**RE: Santa Monica Place (Senior Assisted Living/Memory Care)
East End of Tract 3
Grading and Drainage Plan
Engineer's Stamp Date 10-16-2015 (File: D18D054B)**

Based upon the information provided in your submittal received 10-23-2015, the above-referenced plan is approved for SO-19 Permit. The Grading Permit and Building Permit are approved with the following conditions:

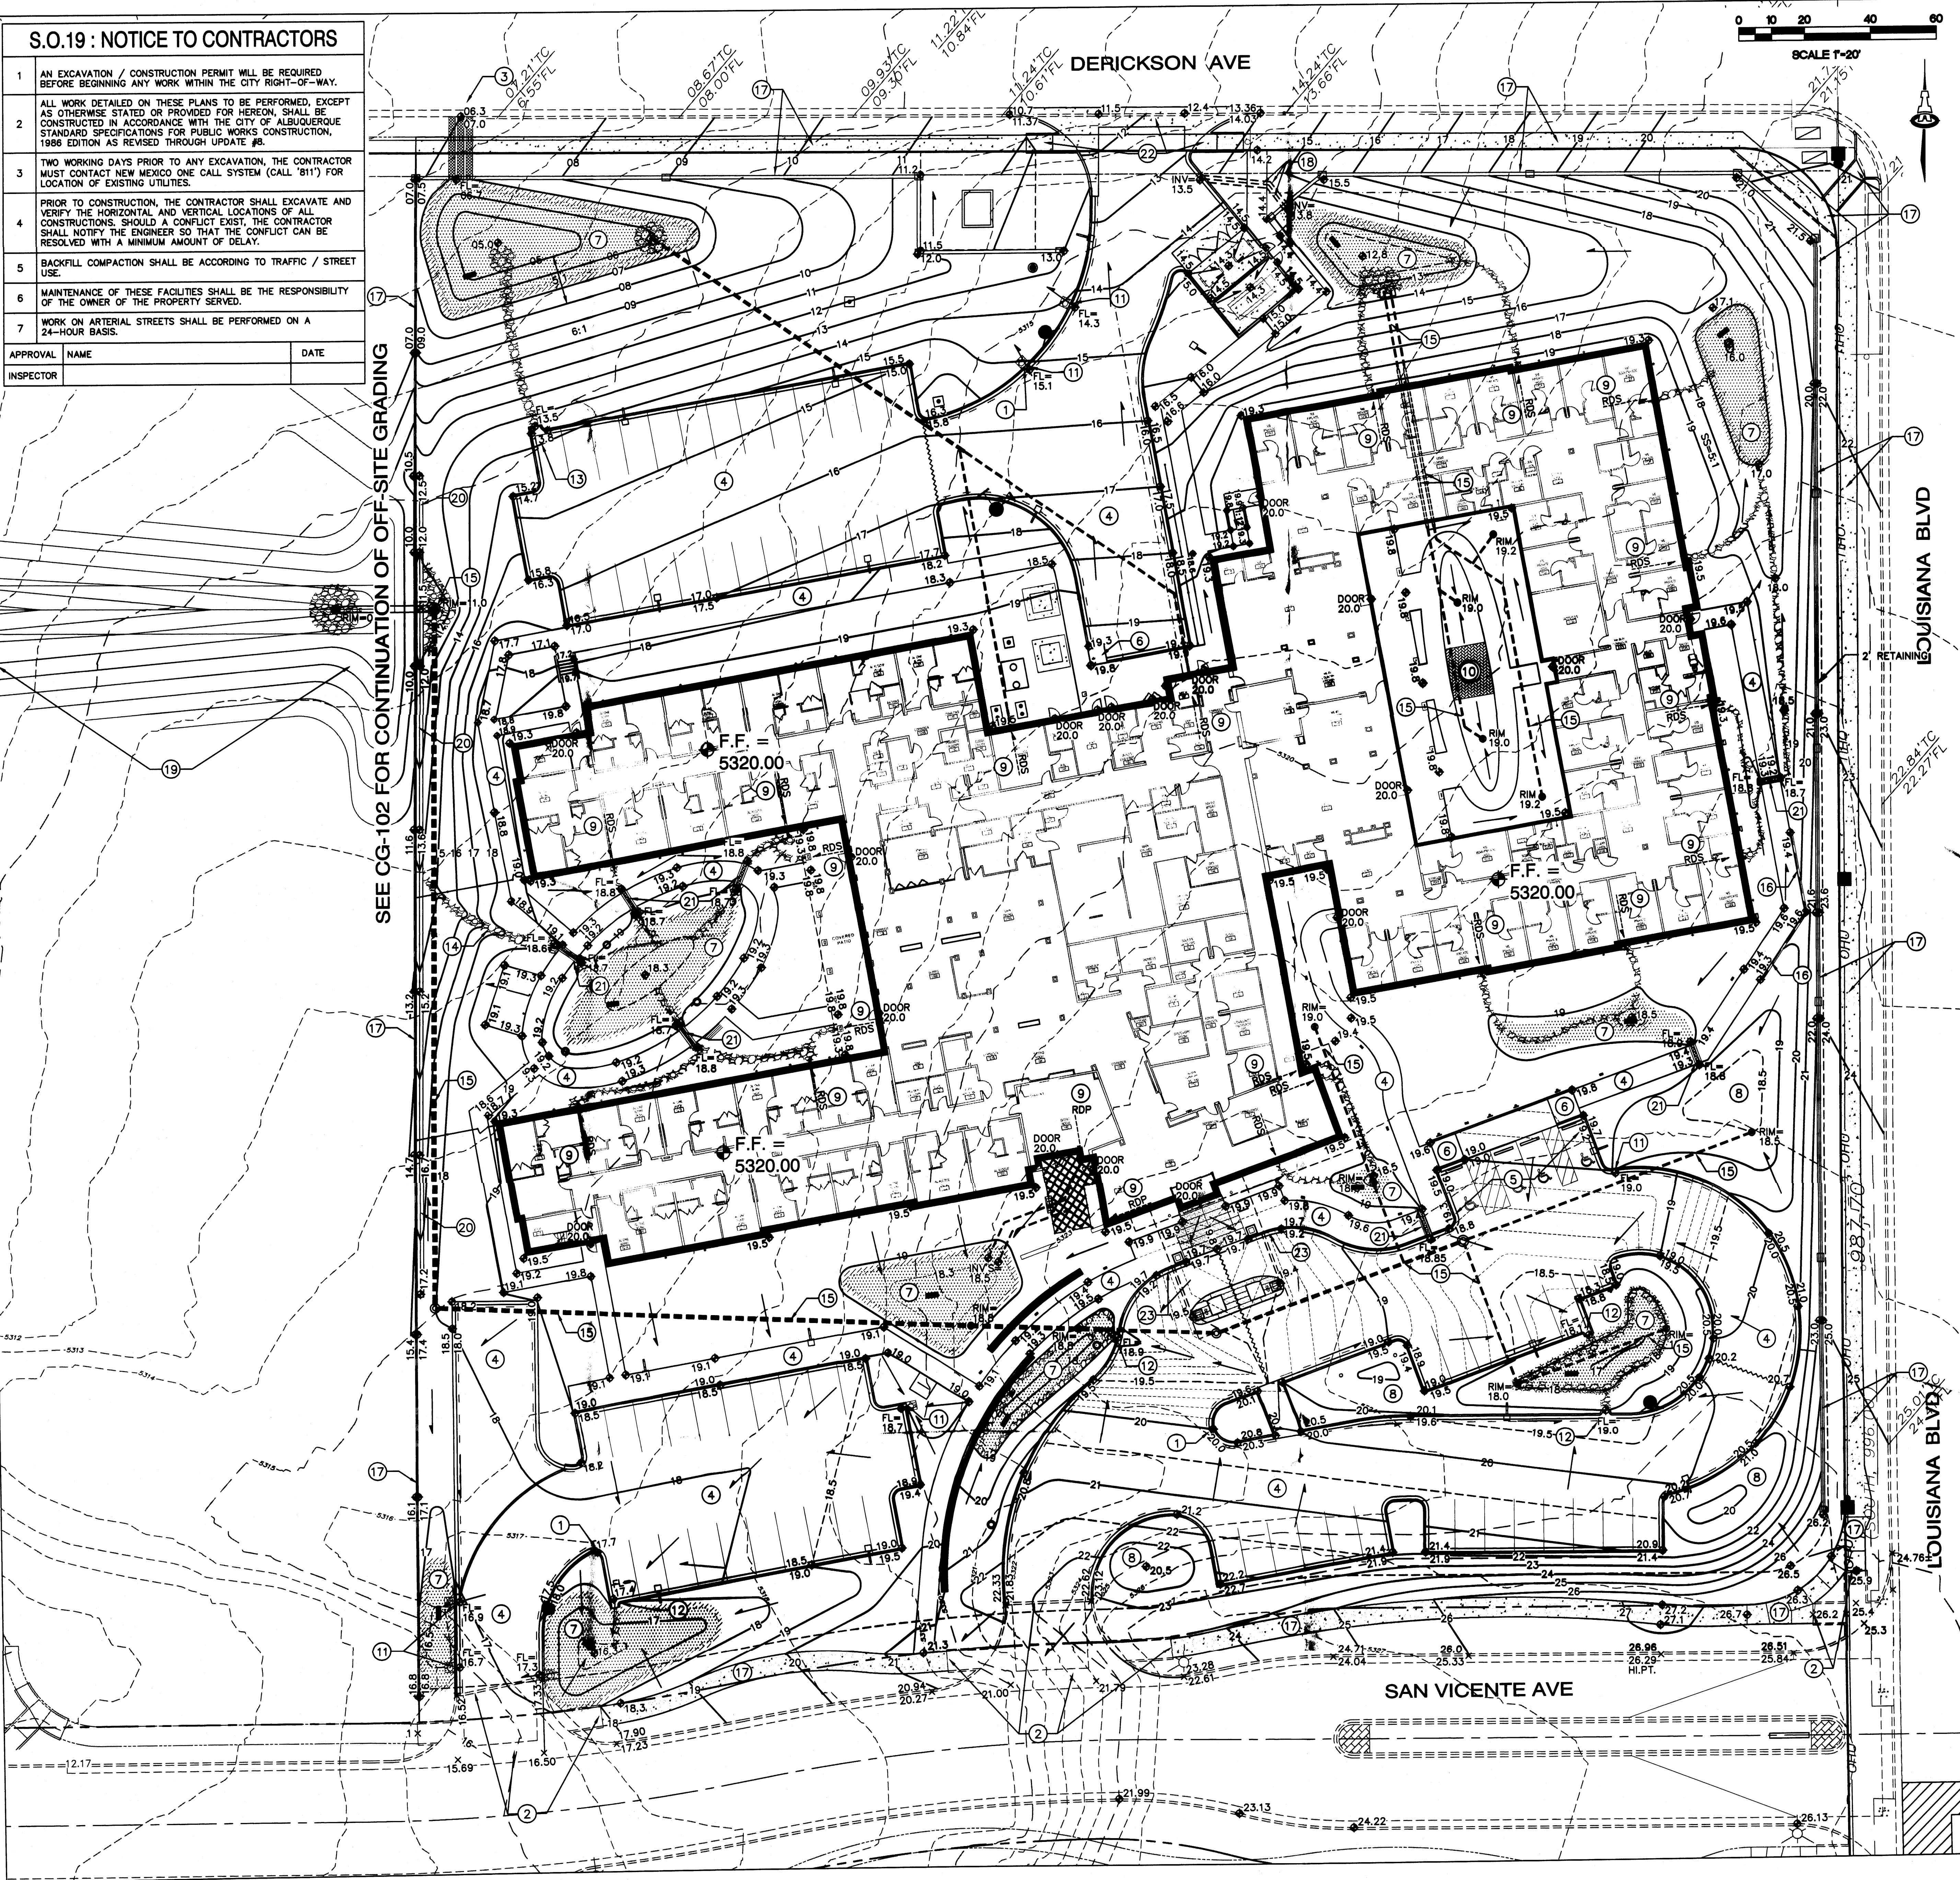
- Specify class IV RCP for the 24" storm drain that will be placed under the retaining wall (or other class only if justified).
- It is assumed that the hatched rectangles shown within the ponds are the percolation pits referenced in Keyed Note 7 on Sheet CG-101.
